Application H16-0484-19
Location Land adjacent: Green Lane Spalding PE11 2YD
Proposal Change of use from wasteland to site for 10 static caravans as low cost rental units

Name Rights of Way & Countryside Access
Address Environmental Services - Andy Savage Lincolnshire County Council Unit 7, Witham Park House LN5 7JN

PLANNING APPLICATION REFERENCE NO. H16-0484-19

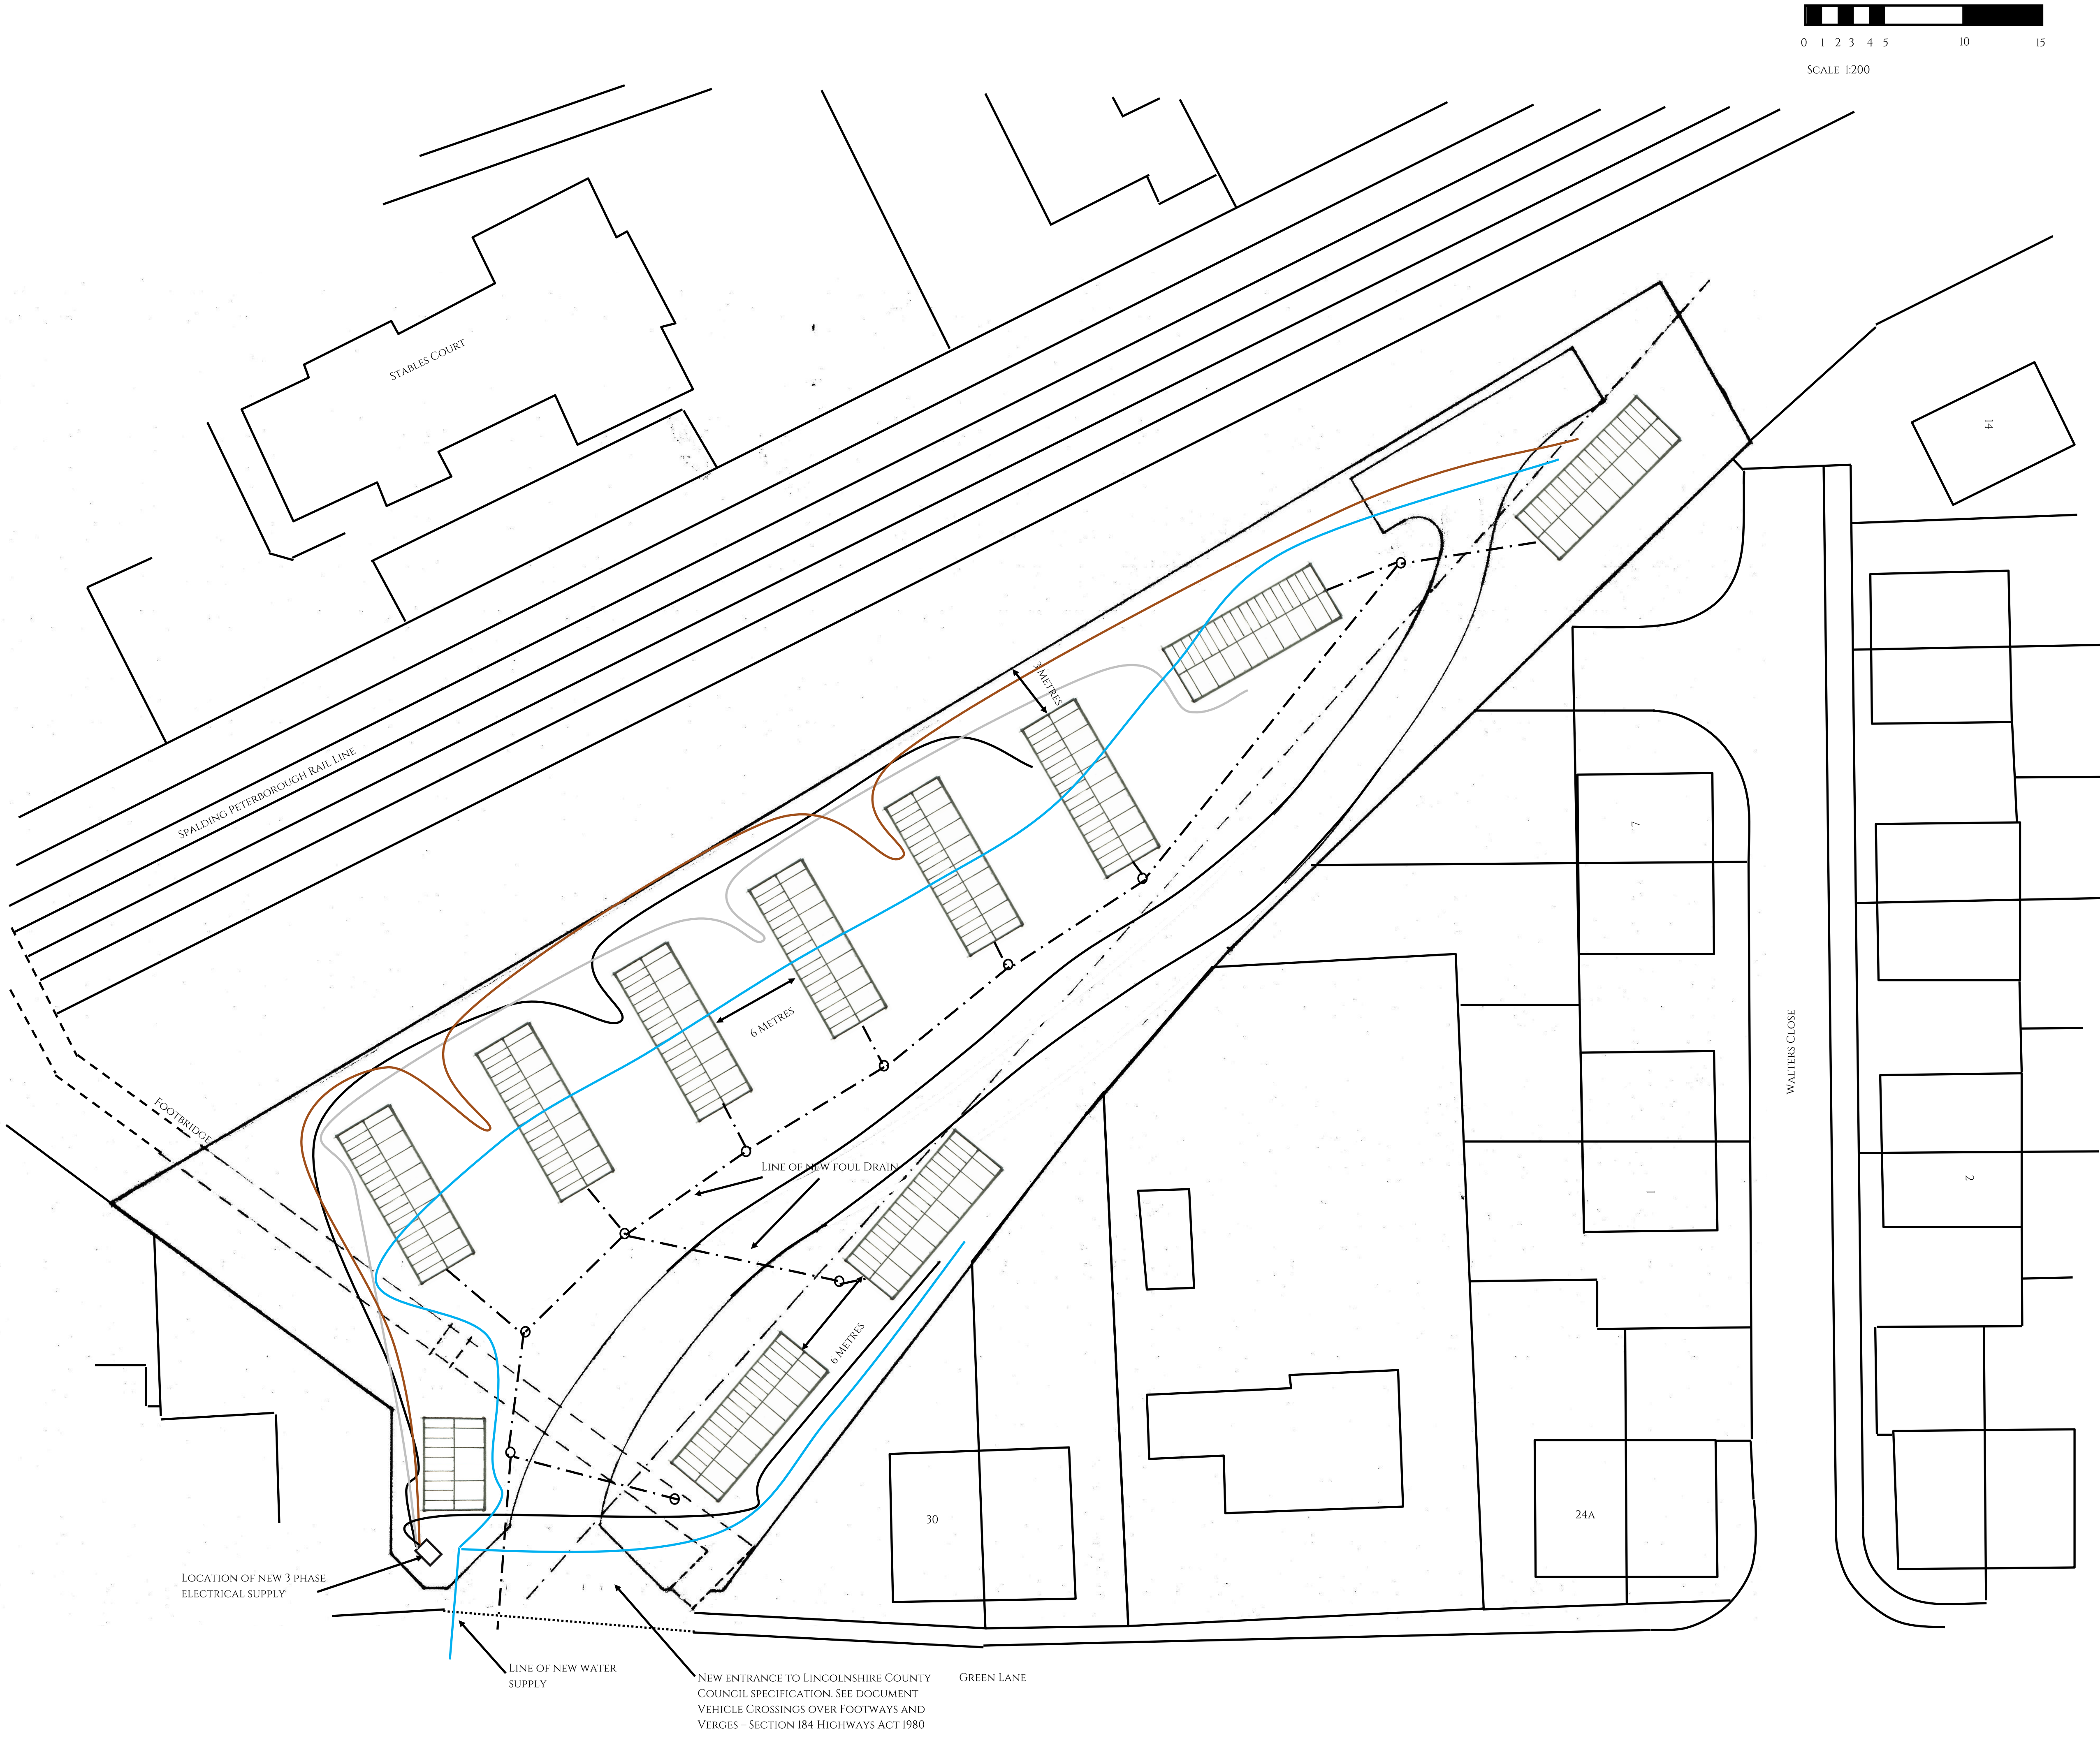
iii/ Further information is required regarding the configuration of the new entrance and the provision of access to and from the footbridge to enable more detailed comments to be submitted.
